Proposed Able Marine Energy Park, Killingholme

Summary of Oral Representations by Associated British Ports at Road Traffic Hearing

22nd October 2012

Junction C
Proposal for Humber Road / Rosper Road

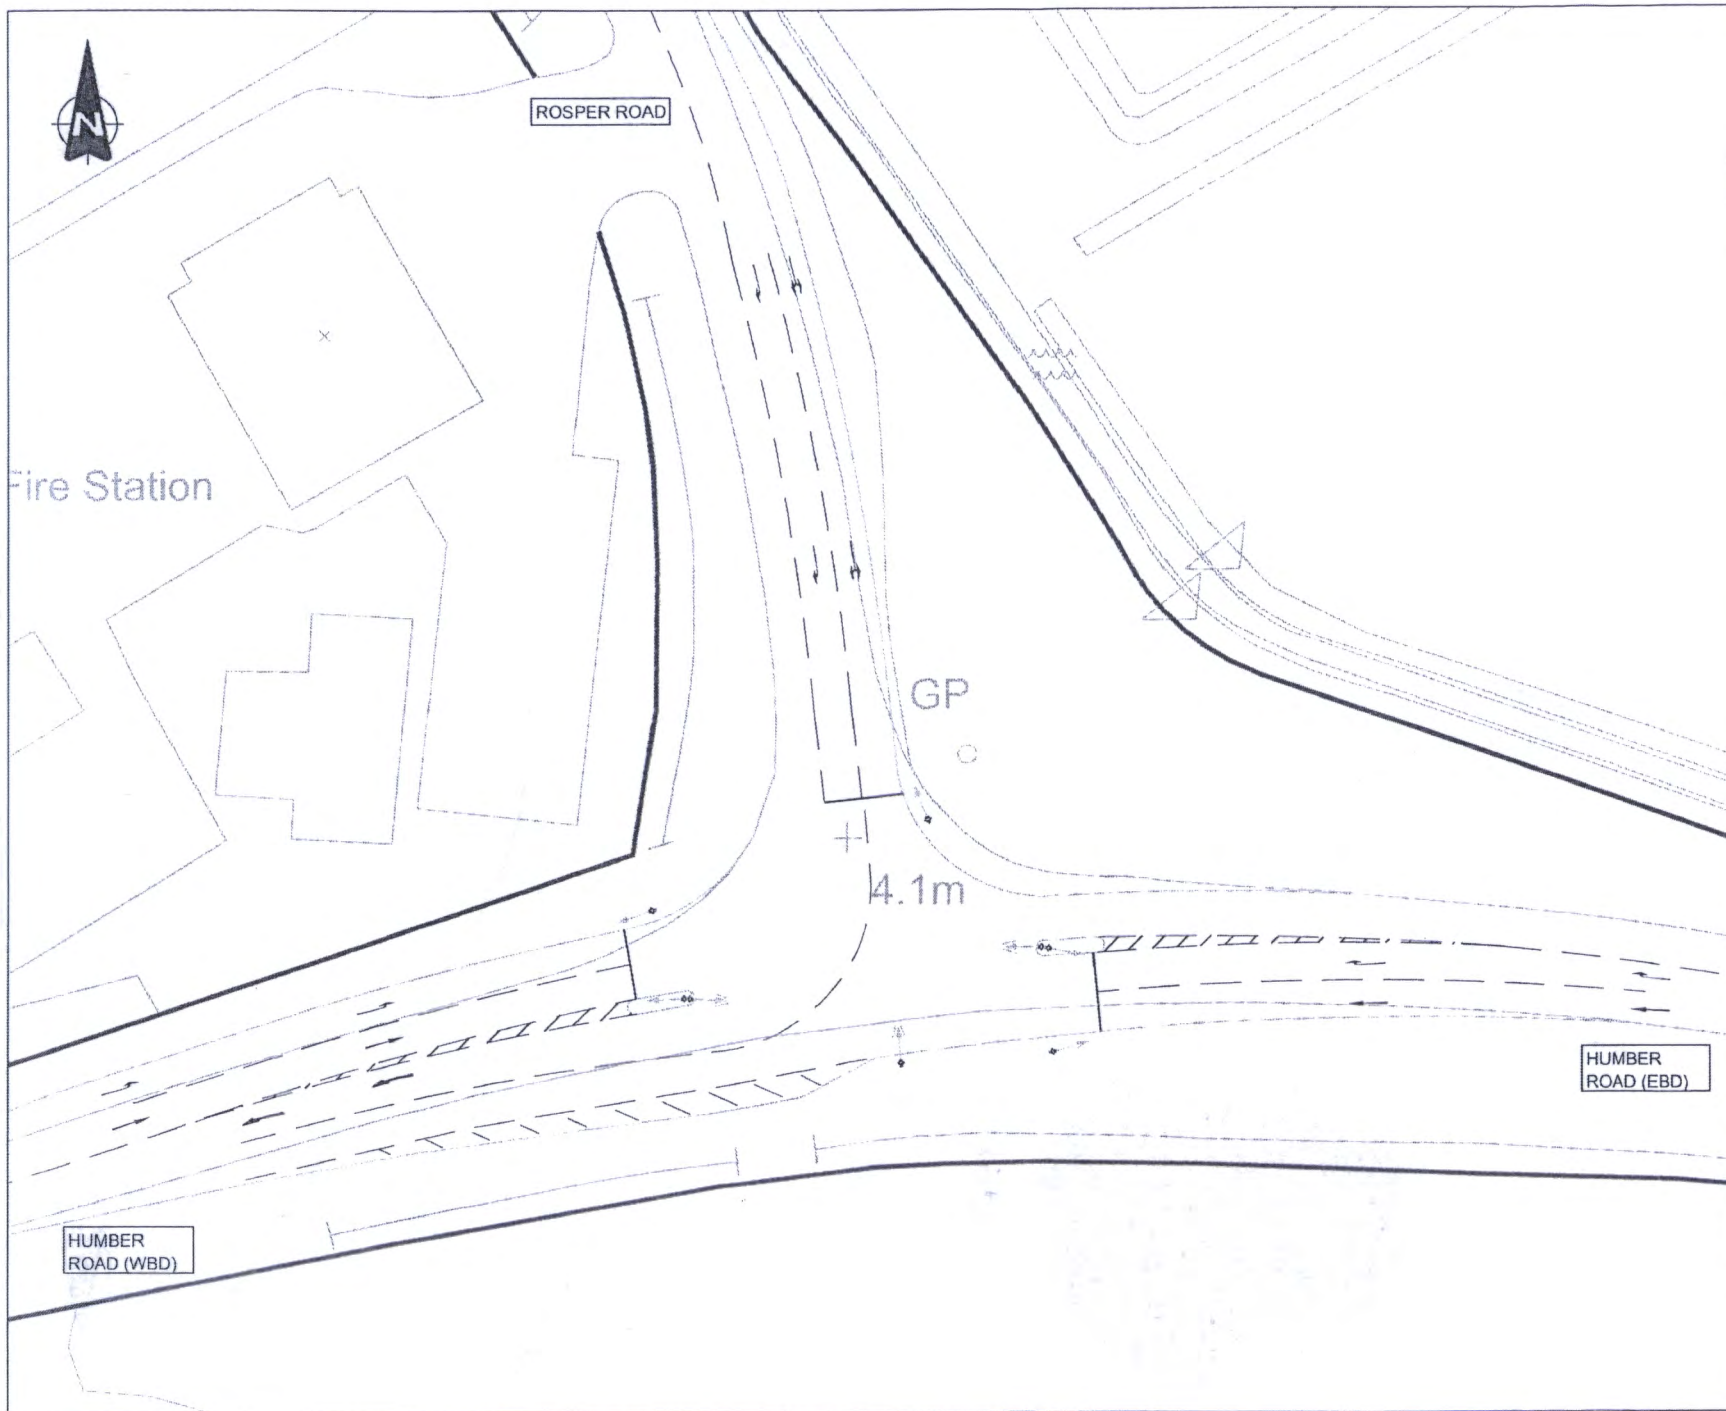
The mitigation works proposed at the junction would, as currently designed, result in delays to traffic accessing/exiting Port of Immingham. In consequence, they would have a seriously detrimental impact on the operations of the port. Such delays would be occasioned by the introduction of traffic lights at a junction where Port traffic currently has priority and thus where such traffic is not currently subject to any delay/constraints. Mr Tucker had in his June 2012 submission provided a sketch of a junction design which he considered would mitigate the position; however Mr Pickard of JMP (giving evidence on behalf of the Applicant) stated that he had not looked at Mr Tucker's mitigation proposal. When one had regard to the committed growth of the Port of Immingham, the capacity of the junction was significantly exceeded.

- (iv) If any pedestrian were safely to walk to AMEP from Immingham, it would be necessary to introduce a pedestrian crossing at the Humber Road/Rosper Road Junction. Current modelling made no allowance for such a crossing.

6. In the context of discussions regarding the safety of the Humber Road/Rosper Road Junction, Mr Pickard confirmed that the right turn into Rosper Road should be controlled by a right turn green filter. When asked whether the modelling assessment available at the Hearing had taken into account the delay/impact occasioned to oncoming traffic of introducing such a right turn filter, Mr Pickard stated that it had not. It was however, he indicated, his intention to submit further modelling shortly which would reflect this impact. It was put to Mr Pickard that it was unsatisfactory for the Applicant to be submitting fresh traffic modelling at such a late stage of the Examination, when the public/objectors would not have an opportunity to comment upon it or test it at the relevant Issue Specific Hearing.
